Application by National Highways for the A46 Newark Bypass

The Examining Authority's written questions and requests for information (ExQ2)

Issued on 14 January 2025

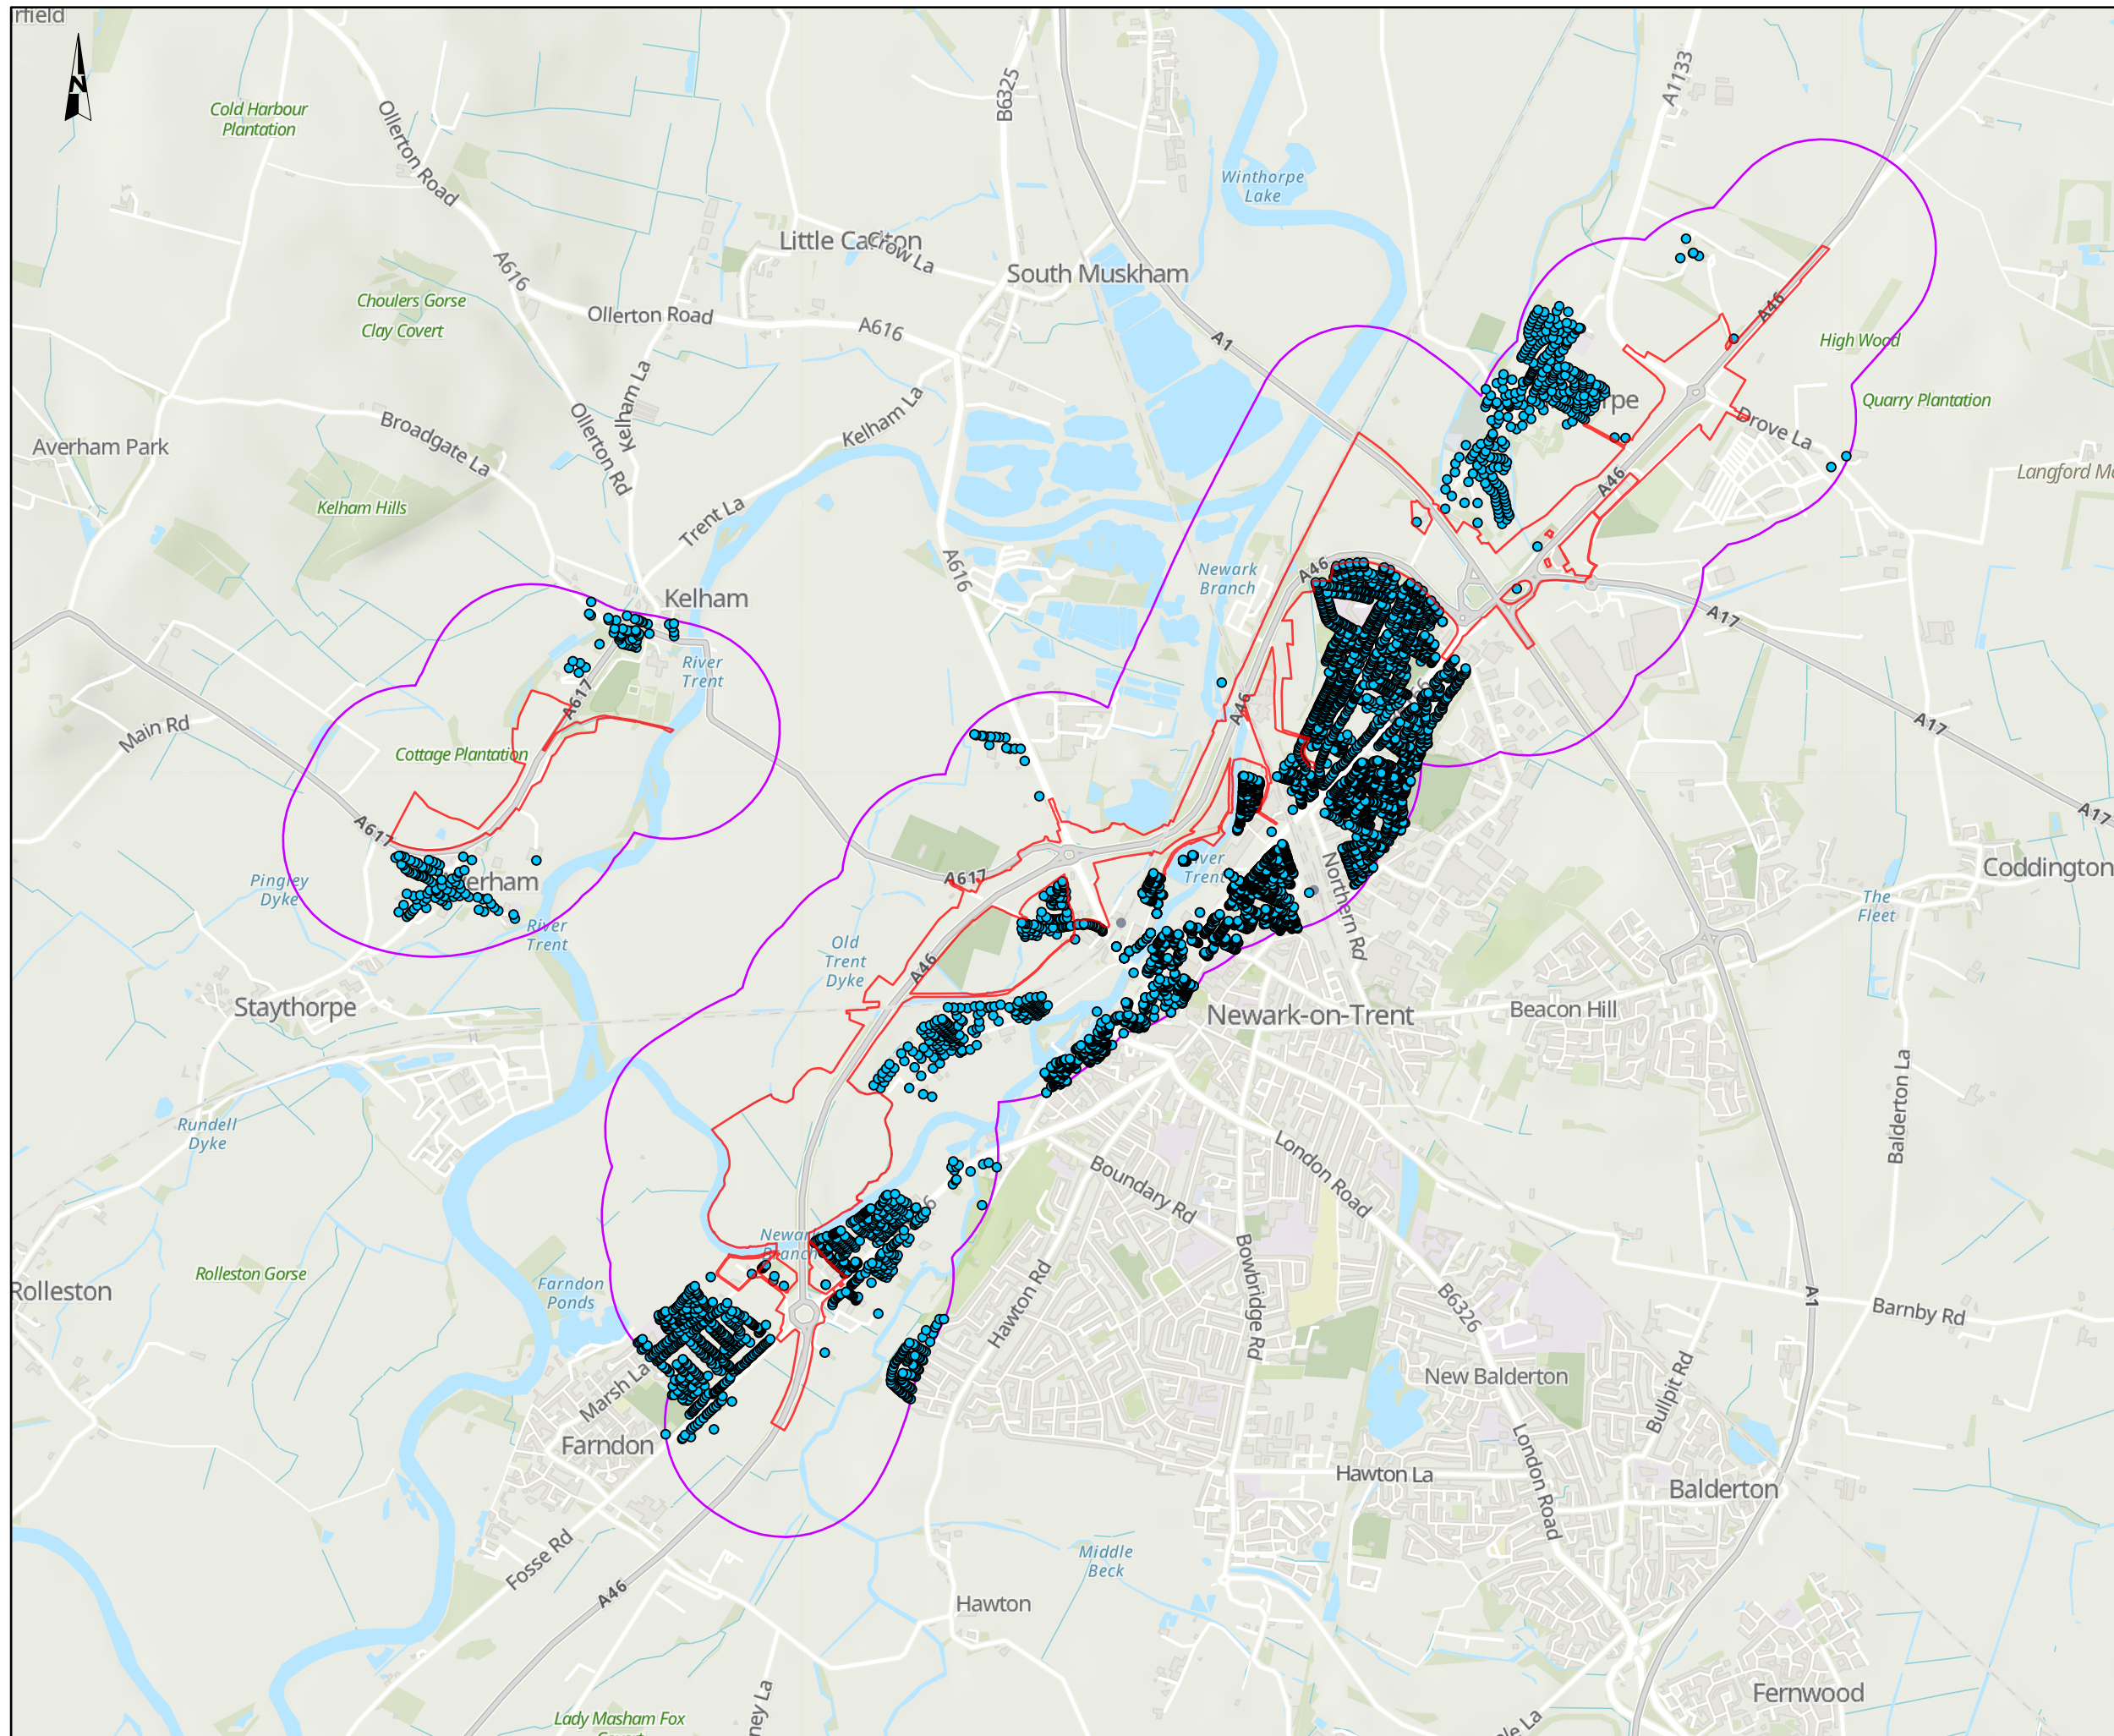
Q13.0.9	The Applicant	ES Chapter 12 Figures a) Please indicate where the village pub, referred to in [RR-079] , is illustrated in the Chapter 12 Figures (e.g. [AS-069] or [AS-070]). b) Should the recently-approved (24/00548/FUL) residential units at Old Stable Yard be illustrated on ES Figure 12.3 – Residential Properties within Local Impact Area [AS-068] ? c) Please clarify where the residential unit which is indicated as being near the former Mint Leaf restaurant on ES Figure 12.3 [AS-068] is located.
